Your Ref :
Our Ref : AW/238/15/NMA

Application for a non- material amendment following the grant of AW/298/14/HH for roof material amendment to rear extension from flat roof to glass roof
231 Aldwick Road, Bognor Regis, ,

Drawing Number 099/86556, Page 4 of 6 - Proposed Plan & Door Detail - Dated 01.07.15
Drawing Number 099/86556, Page 5 of 6 - Proposed Elevations - Dated 01.07.15
Drawing Number 099/86556, Page 6 of 6 - Proposed Elevations - Dated 01.07.15

Drawing title: **Proposed Unit Elevations**

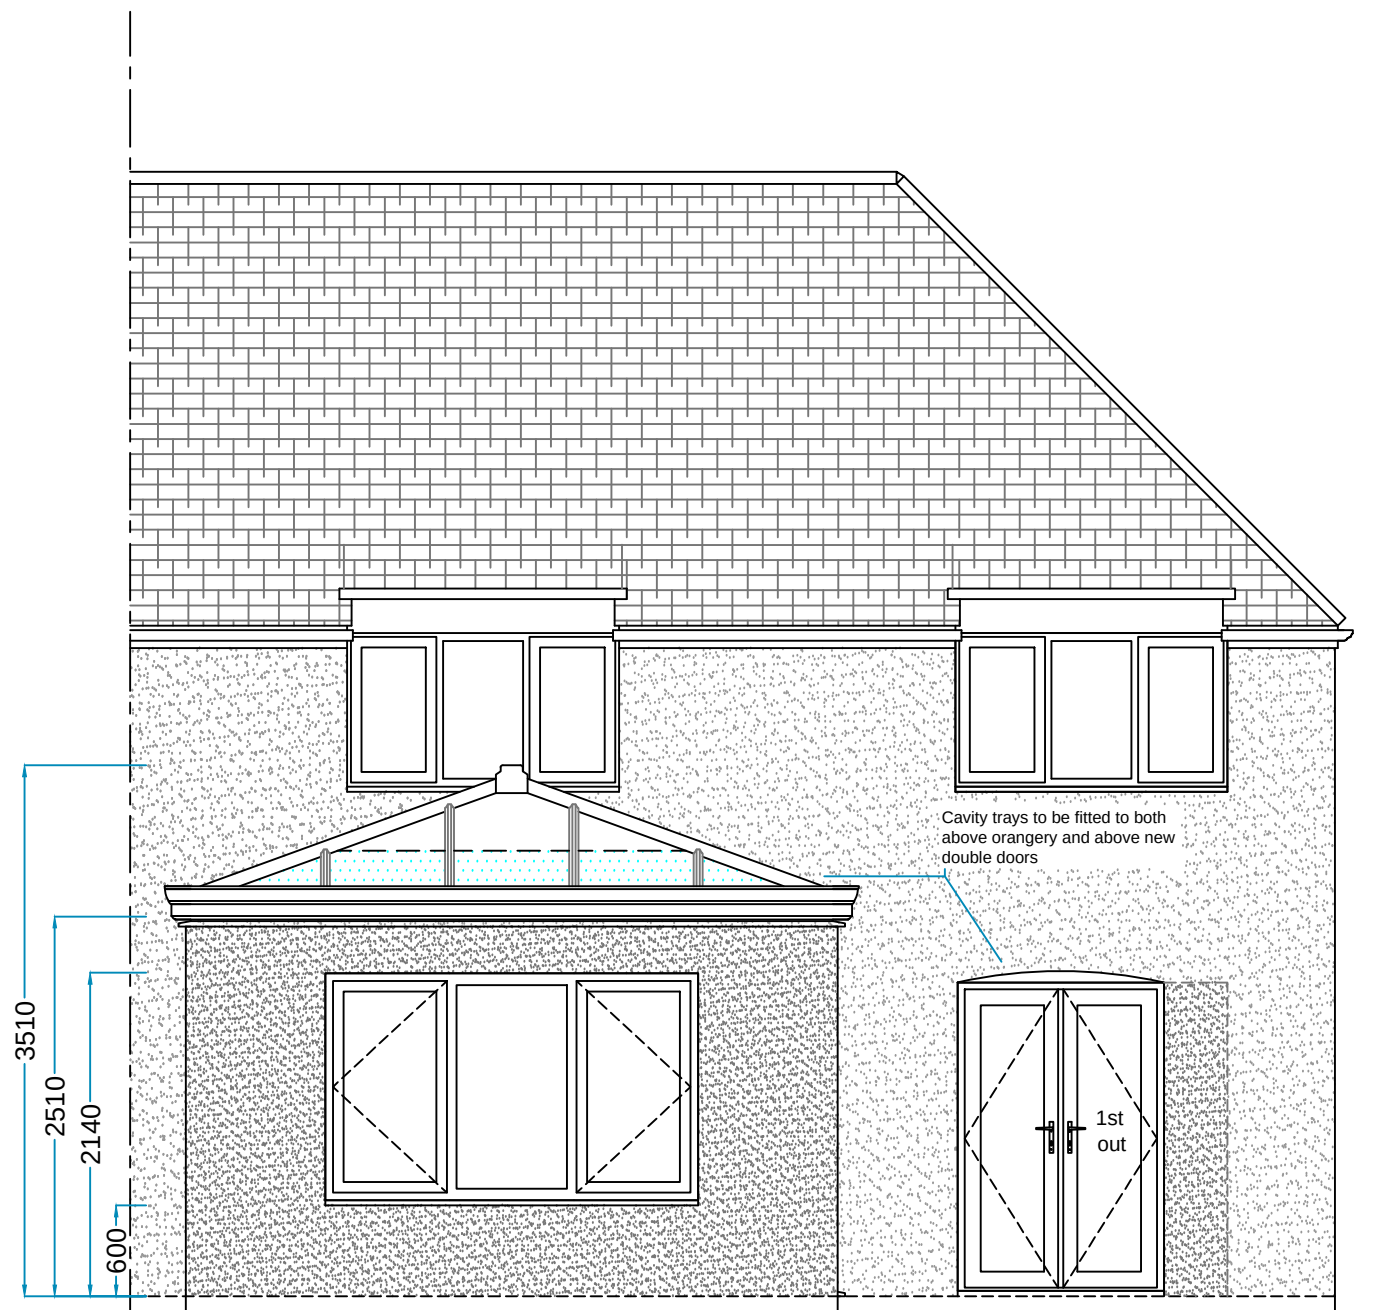
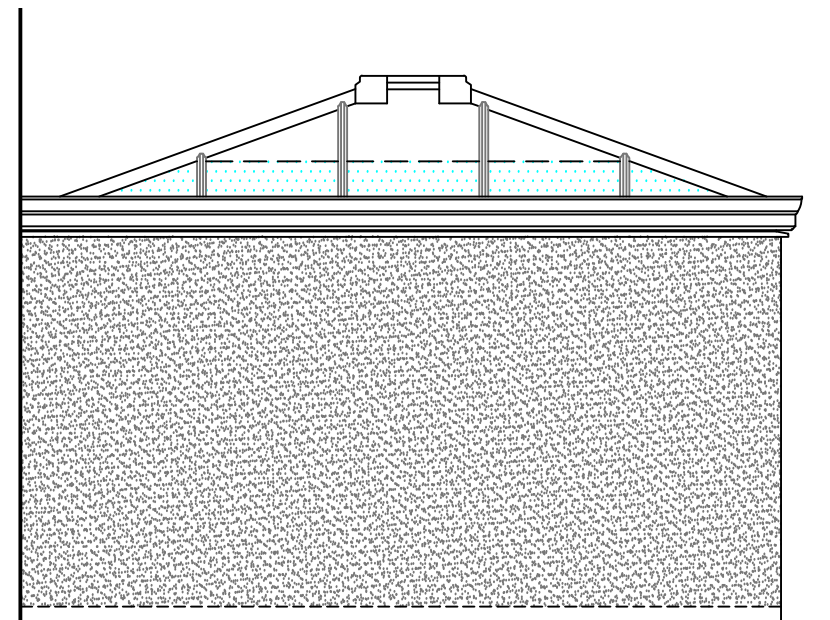
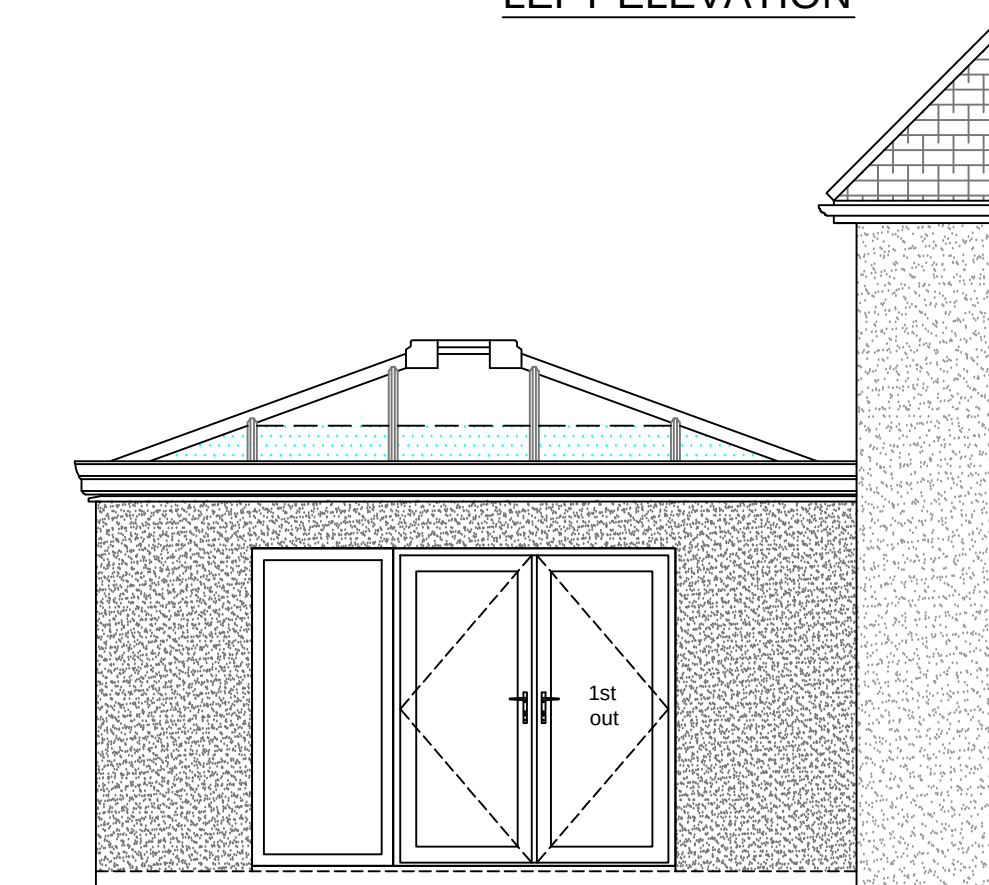
From the information submitted the Council is able to accept the change to the roof of the rear extension from a flat roof to a glazed hipped roof and also the minor revisions to the fenestration of the rear extension. It is not considered that the revisions amount to a material change to the approved scheme and as such a further planning permission is not required.
